From: Shelly Barrett <[REDACTED]>
Sent: Thursday 24 June 2021 12:55
To: Appeals2
Subject: ABP-310347-21 - Submission
Attachments: Bord Pleanala Submission 3 Gilford Avenue.docx; DWG.2119-001.pdf; DWG.2119-002.pdf; Bord Pleanala Observation No 9.docx

Your Case Number: ABP-310347-21

Planning Authority Reference number: 0135/21 (DCC)

Address : No 3 Gilford Avenue Dublin 4 – Declaration

Existing Ground Floor Plan

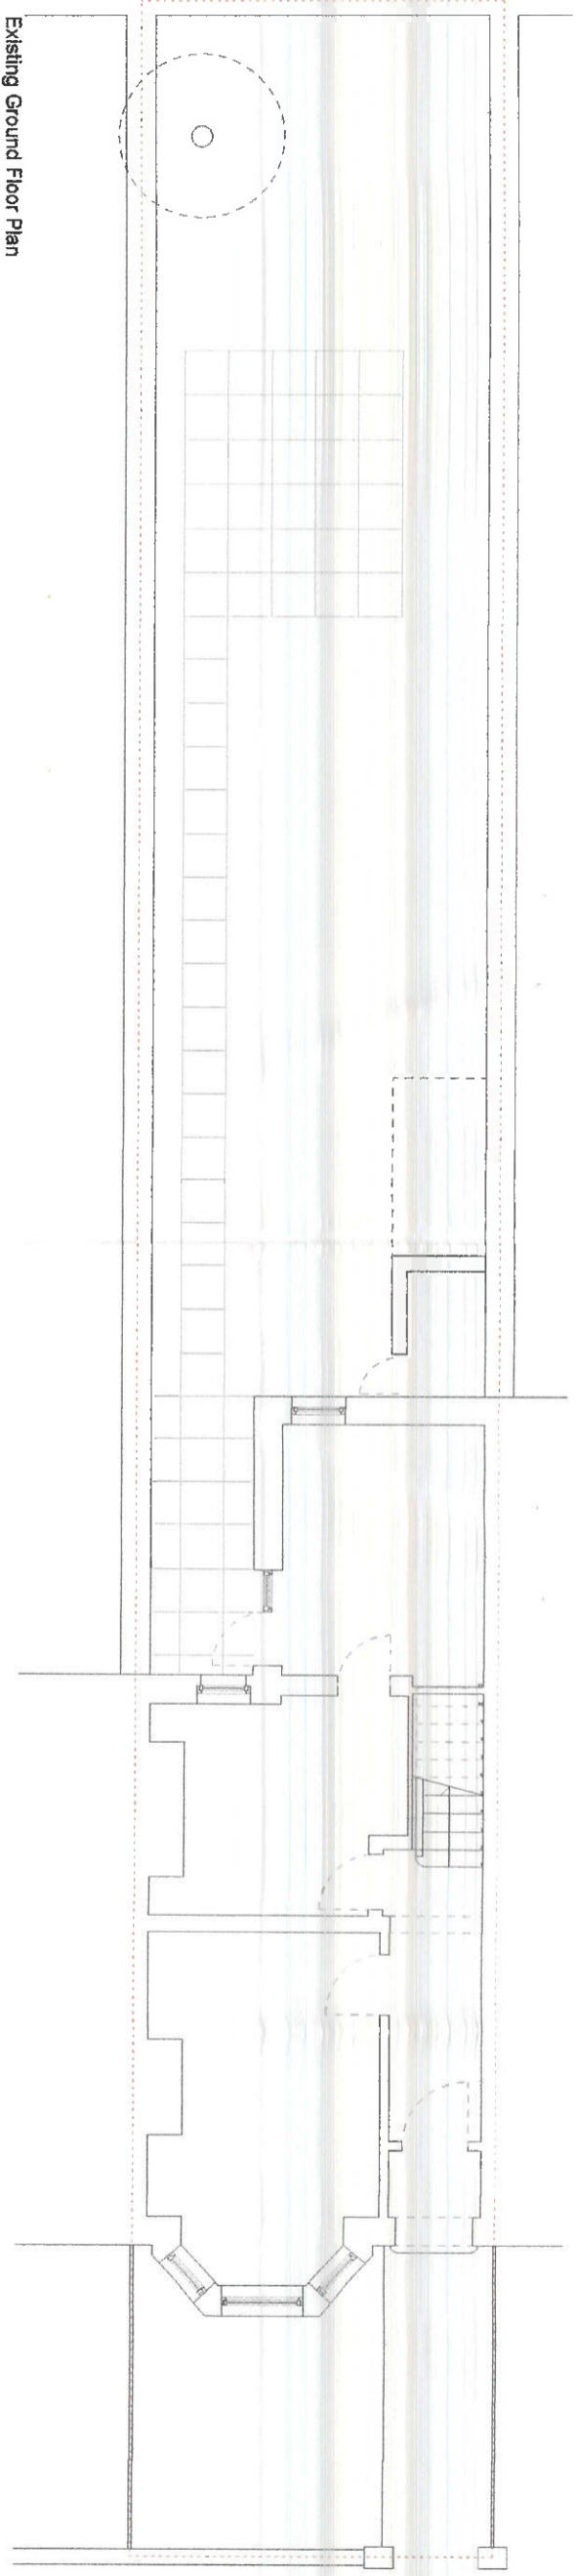
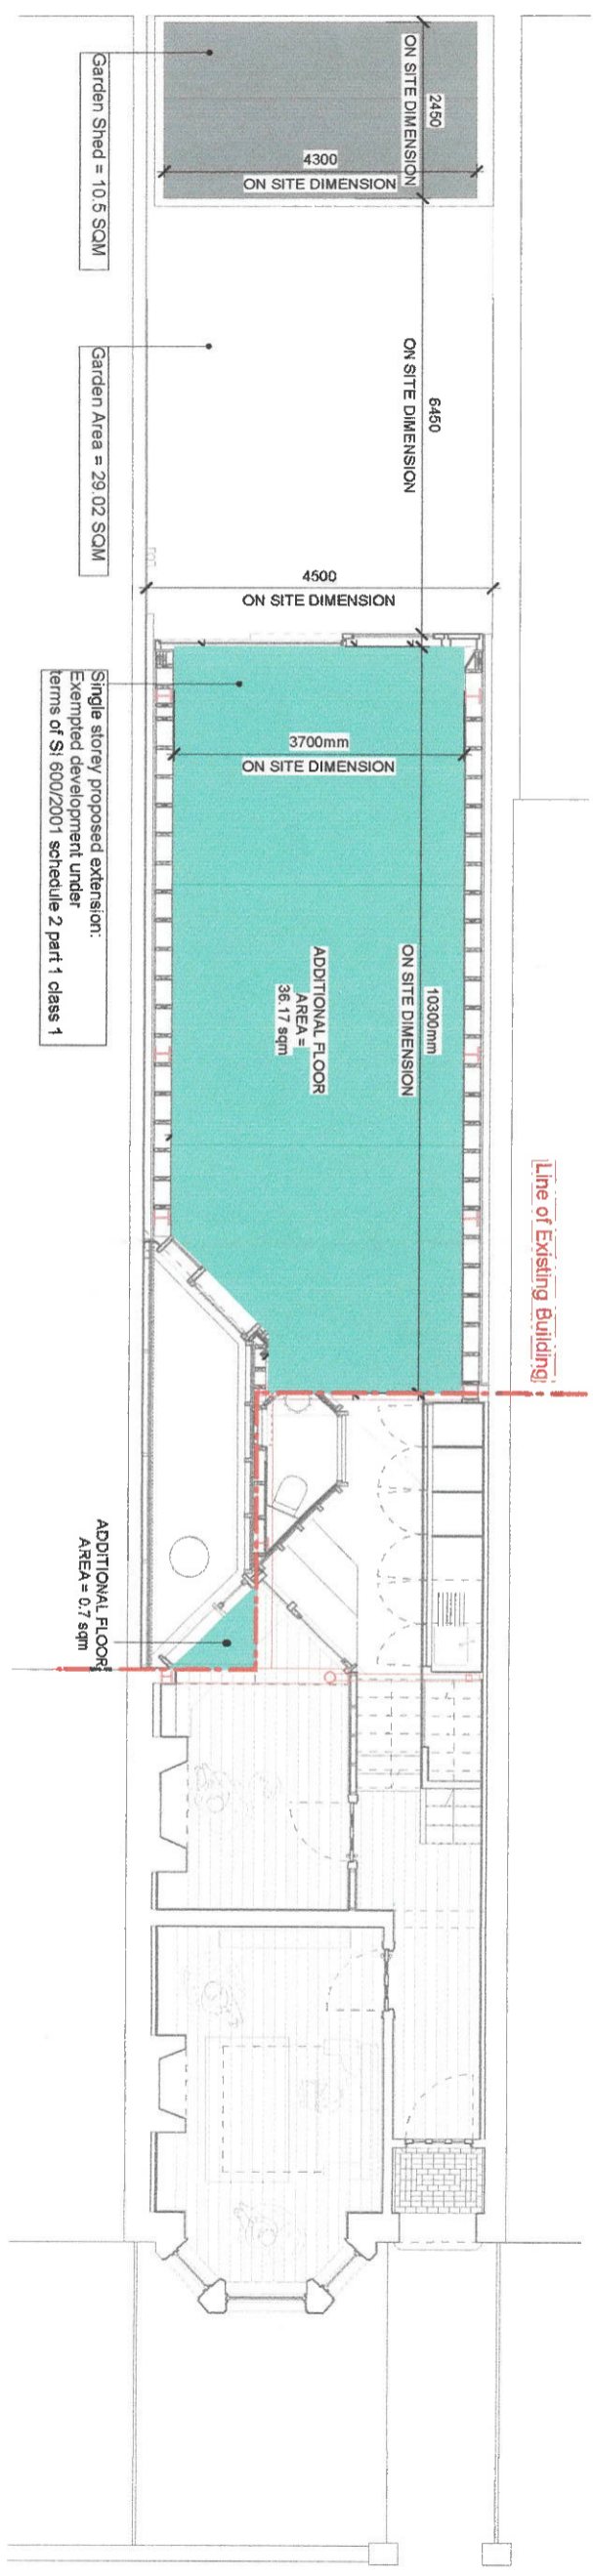
The roof of the extension is a hybrid roof and the flat roof section of the hybrid roof is at 5.79 metres above ground and the rear wall of the house is 4.33 metres above ground – yet this was not mentioned in the subsequent recommendation.

The height of the southern wall of the extension to No 3 Gilford Avenue extends to 5.79 metres above ground and the rear wall of the house is 4.33 metres above ground – yet this was not mentioned in the subsequent recommendation.

My calculation of the area of the extension at No.3 was based on the width of the plot of No 1 Gilford Avenue which is 5.02 metres wall to wall. The numbers of bricks on the front elevation of the two houses are the same and the plots are orthogonal. I fail to see how this dimension was reduced

to 3.7 metre internal dimension given that a simple timber frame construction was used in the construction of the extension to No. 3.
